Re: Planning Application Number 3/2025/929 17 Redwood Drive, Longridge

Planning Application Reference No.: 3/2025/0929

Address of Development: 17, Redwood Drive, Longridge, Preston

Block Plan
1:500 Scale

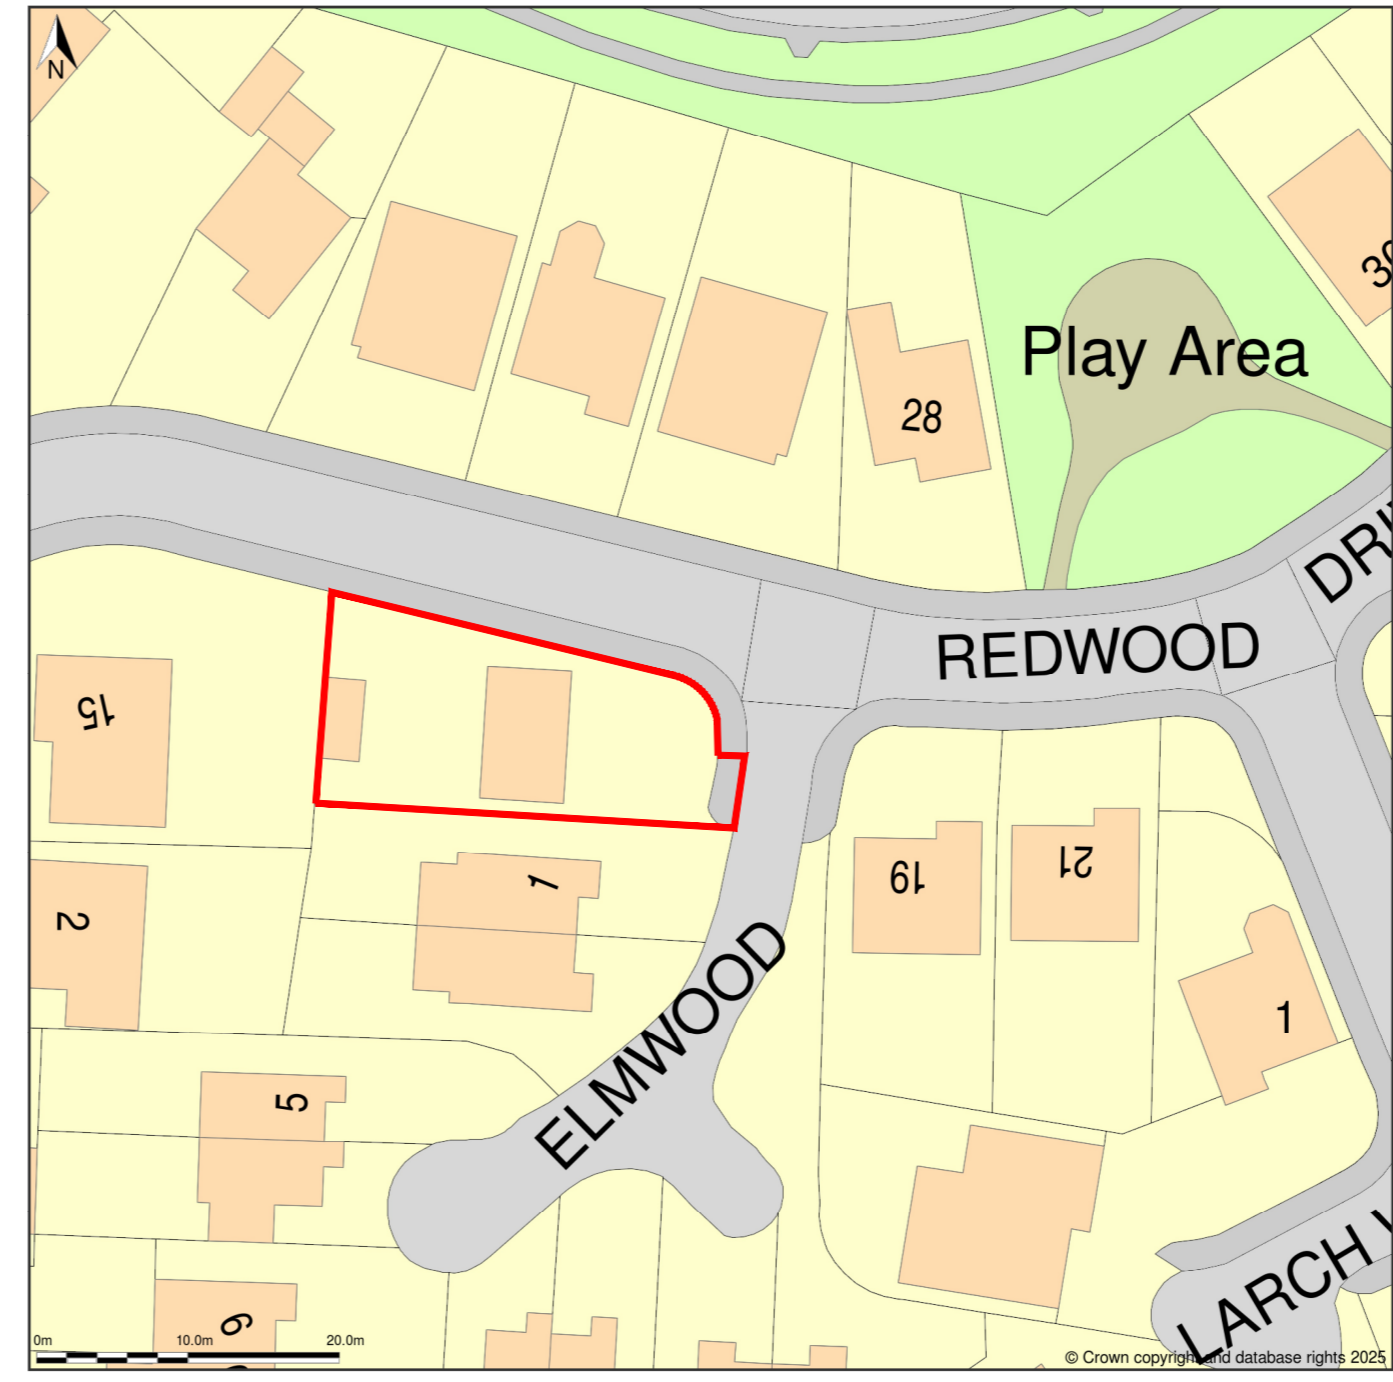
1) The fact that residents living in the cul-de-sac, Elmwood, have not been included, with the exception of No.1 Elmwood, in the list of neighbour notifications. Looking at the site plan it is obvious that Elmwood would be impacted by this development. It is a small cul-de-sac, and the house entrance and front of No.17 Redwood Drive face directly into Elmwood, despite the street address.

Proposed Site Plan
1:50 Scale

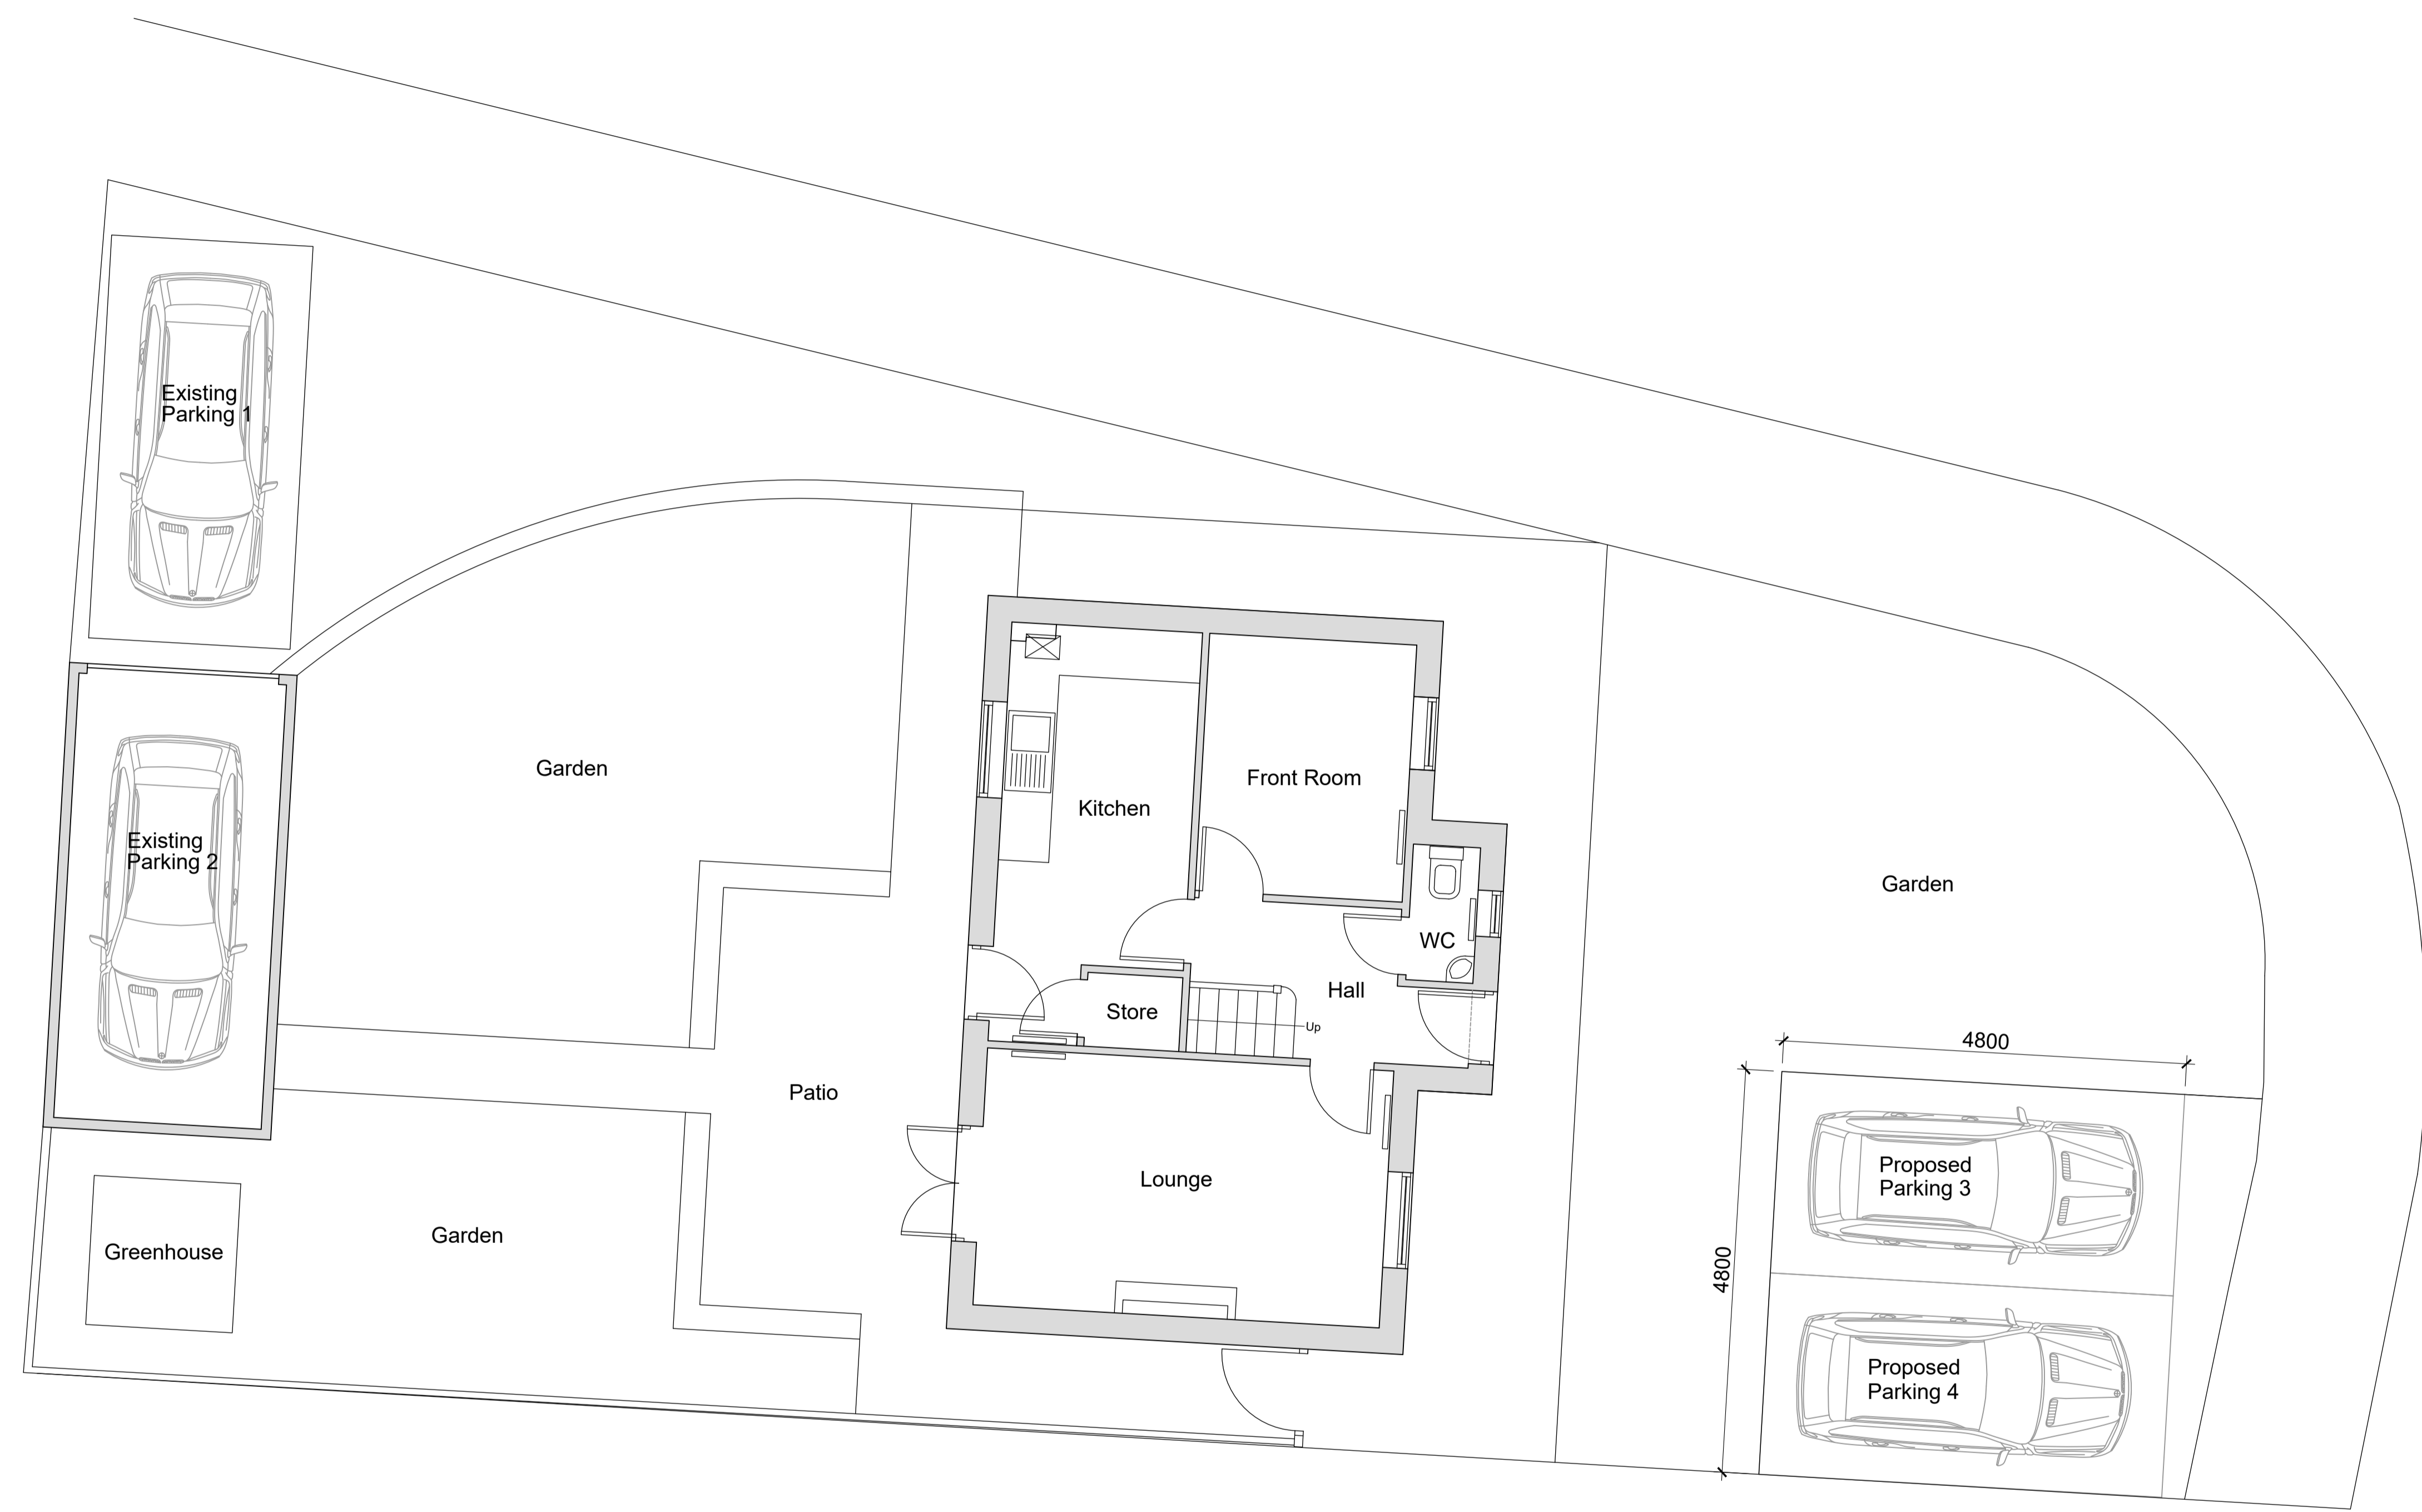
The Planning Application form says no altered vehicular access, there will need to be a new vehicular access to the proposed parking spaces.

Paragraph 4.5 of the planning statement says that there are no changes proposed to the property. In fact there are two parking spaces proposed on the front garden of 17 Redwood Drive. These spaces will have to be accessed by a dropped kerb and driveway. This is a change that should be acknowledged. This will have a negative impact on the appearance of that part of Redwood Drive.

I am also concerned about the visual impact of the plans. The proposal involves altering the front garden to create parking spaces and removing a mature tree. These changes would noticeably alter the appearance of the property and the wider street frontage. The grassed areas and tree contribute positively to the appearance of the estate, and their removal would change the established look of the immediate area.

3) There is a large contradiction between the planning application form and the proposed site plan, namely the creation of two extra parking spaces covering the front garden of 17 Redwood Drive. This has been pointed out in the Highways document, which suggests that a further proposed site plan must be submitted before any progression of the proposal.

Comments: Looking at the plans I do not feel this type of change of use is suitable for its location. Possible increase in noise, not adequate parking as paving over the grass is not good for drainage, more traffic on already busy estate, disturbances during the night.

2. Parking: the plans show parking provision for 4 vehicles. This would affect the visual amenity of many, sets a precedent for parking on grass and, if paved, is not an environmentally desirable measure with its negative impact on drainage. Two parking positions are the garage and driveway, which will result in inevitable shuffling as the driveway is immediately in front of the garage. I have never ever seen the garage used for a car since moving here in 1999. The plans show that there is no net increase in the number of parking spaces, which is not true. Experience has shown that owner and tenants have been reluctant to park on the driveway because of the manoeuvring involved (and/or deposits from the trees above). Vehicles are very likely to be parked on the road, opposite existing driveways and, probably, on the pavement, restricting the movement of those using mobility scooters, prams or wheelchairs, making matters unsafe for those vulnerable groups.

- No more than one child should live at the premises.
- The premises should not be used for staff meetings and training.
- Additional children should not be brought to the premises for schooling/educational purposes.
- The proposed car parking should have a porous surface so that it does not increase run off rates.
